A57 LINK ROADS

TR010034

RESPONSES TO DEADLINE 4 SUBMISSION

CPRE Peak District and South Yorkshire Branch

**A57 Link Roads
TR010034**

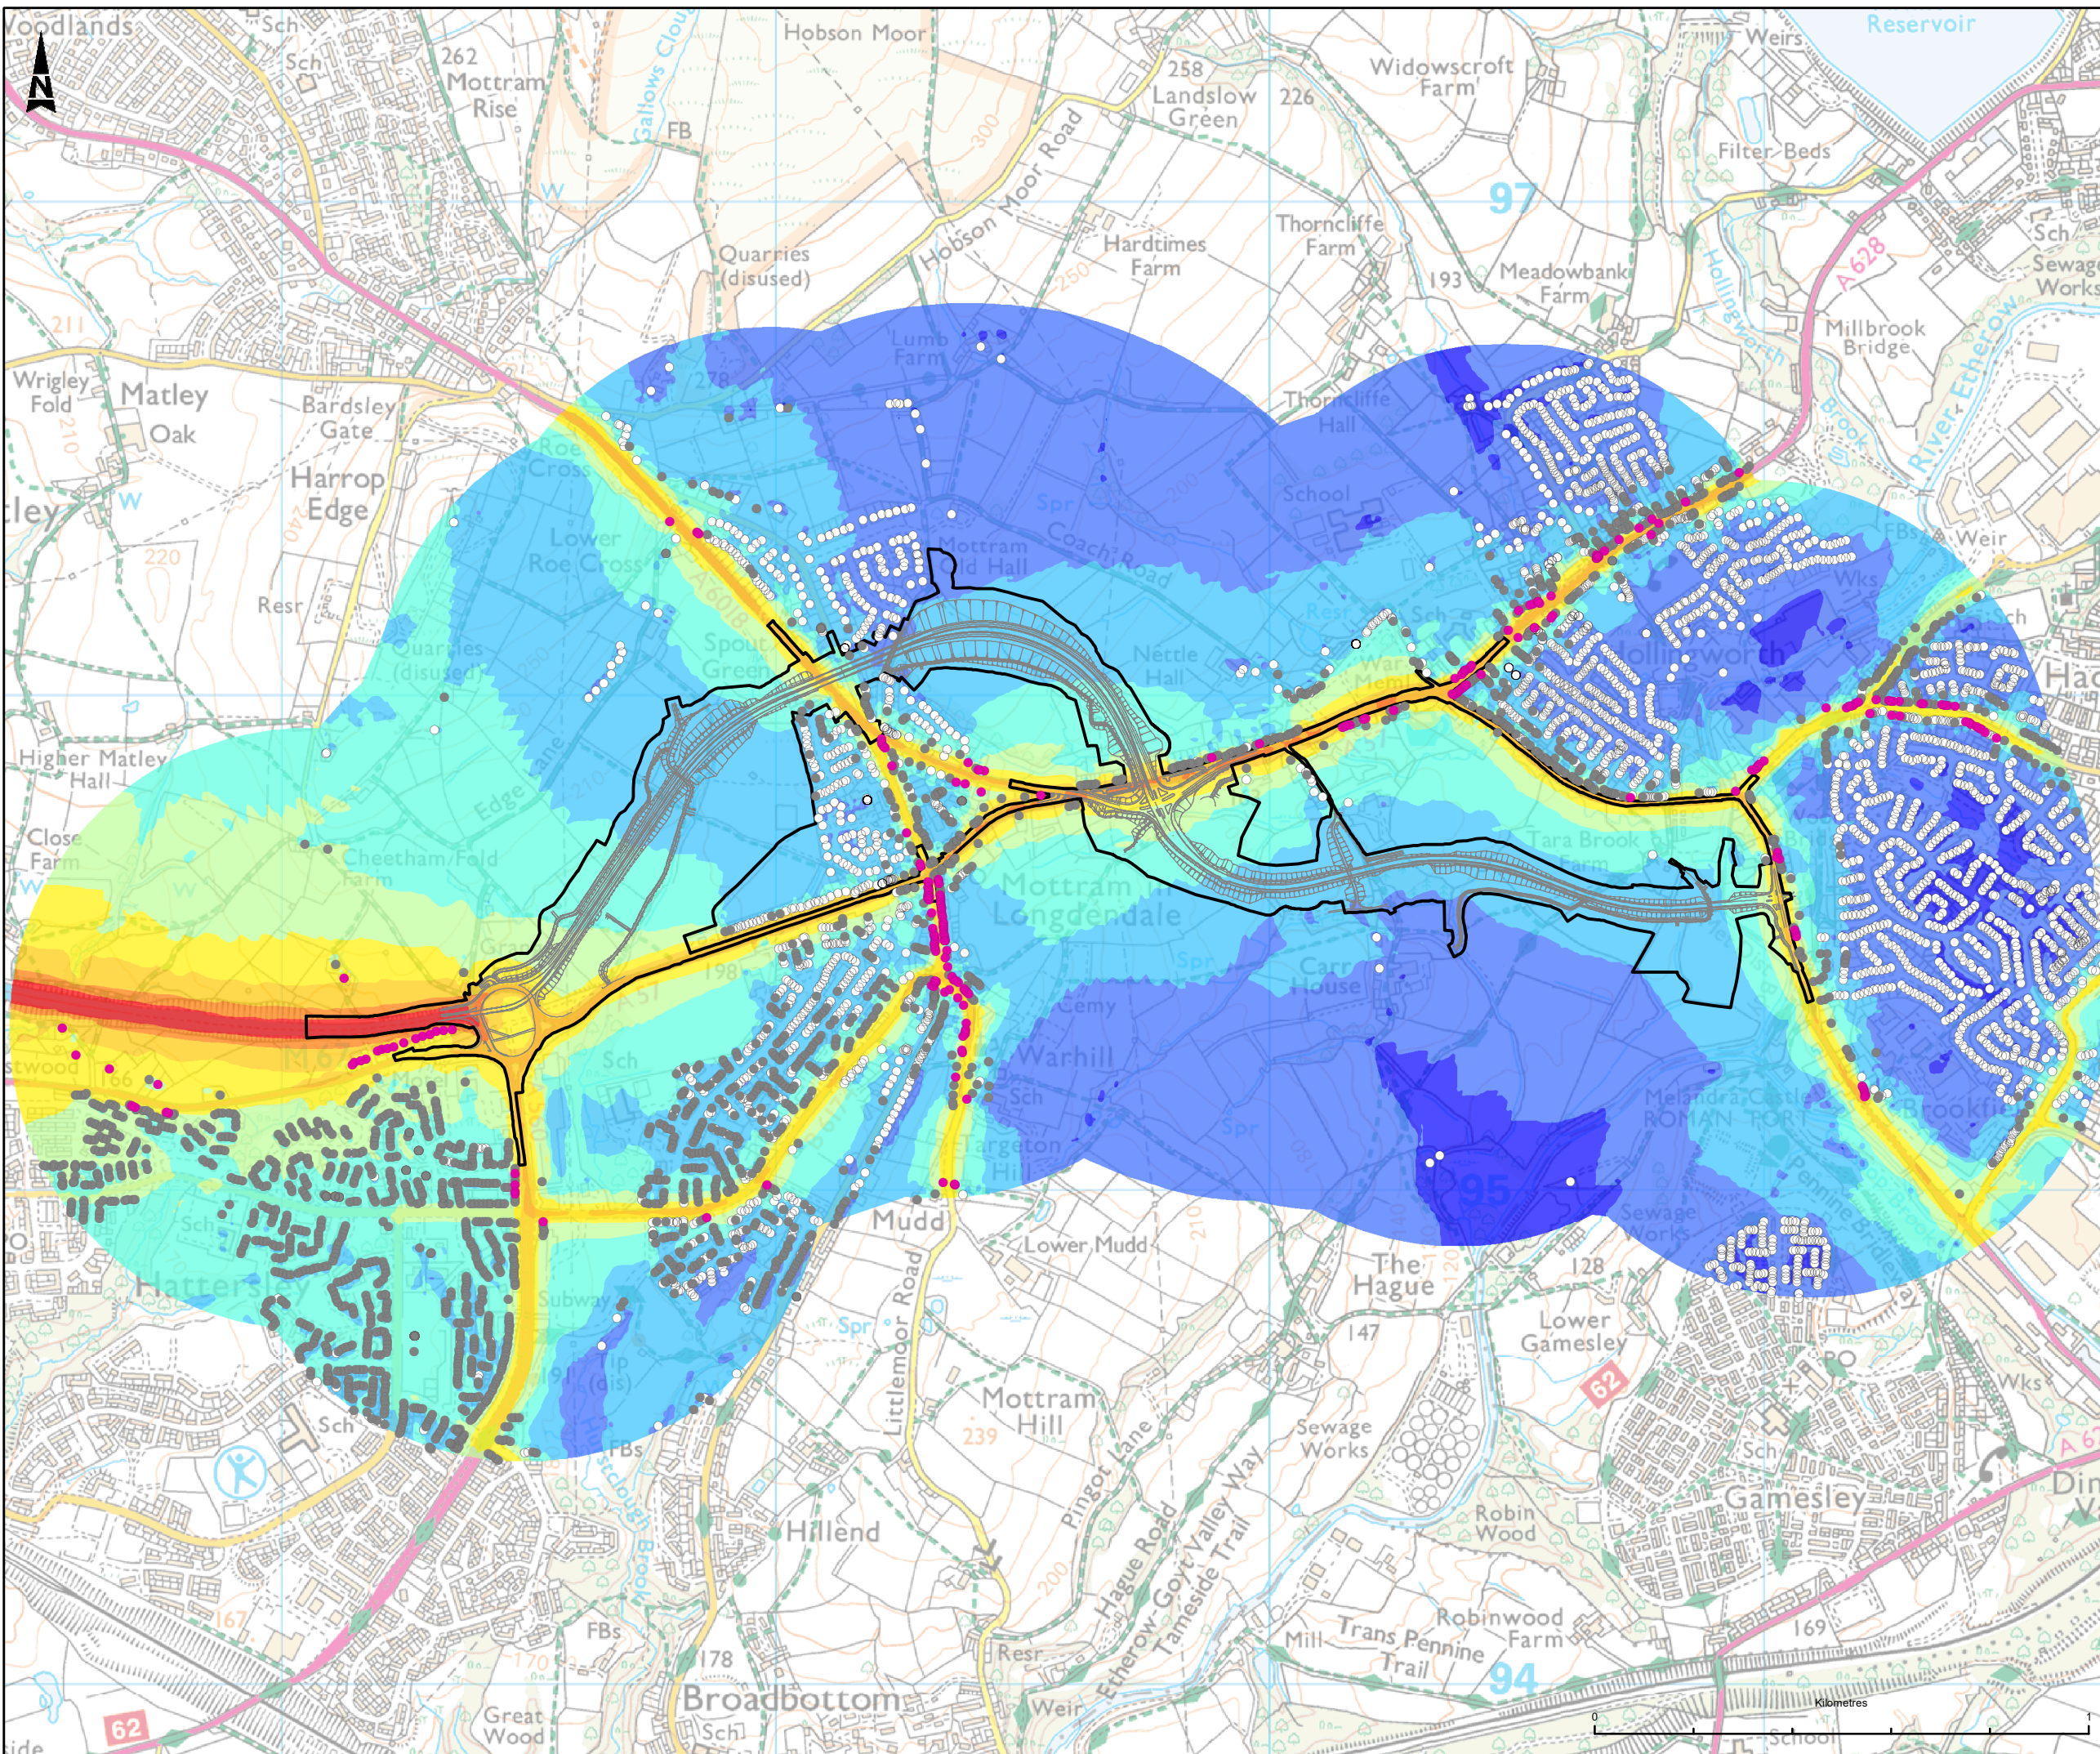
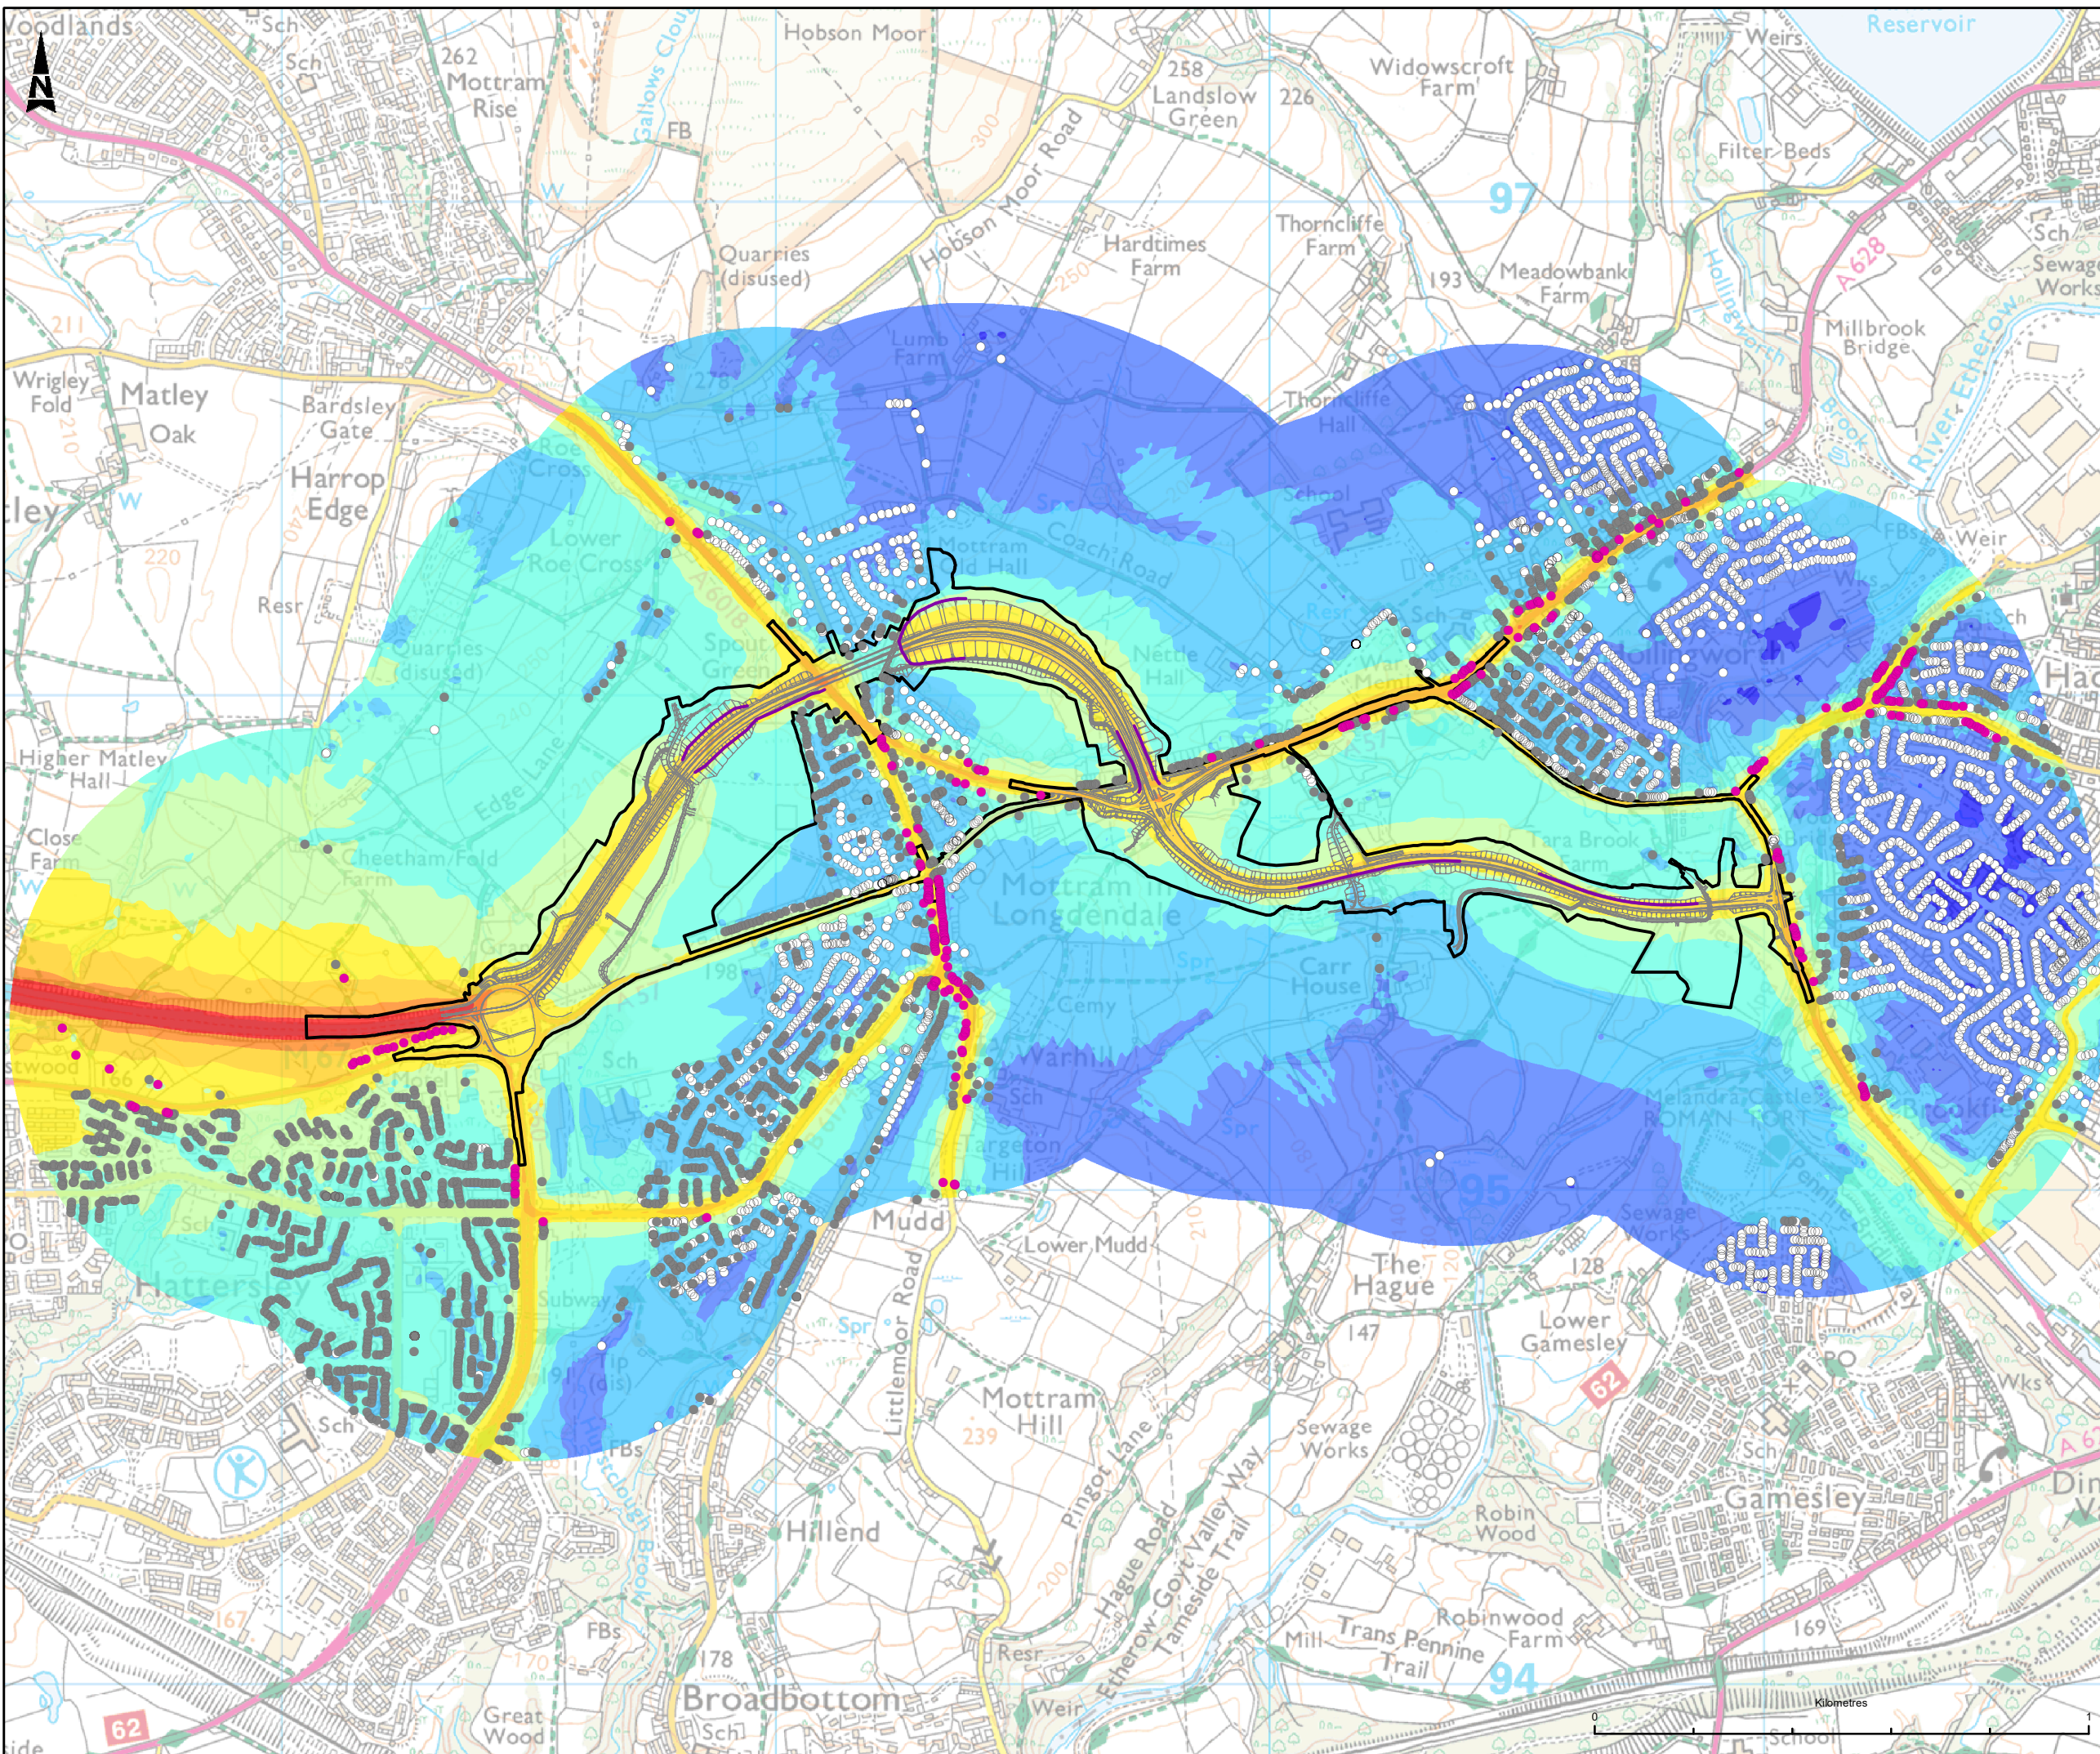
- 1) The assessment in the table and the map of noise contours confirms our statement that the tranquillity in the vicinity of the scheme would be substantially harmed and local amenity impaired for those using the footpaths.
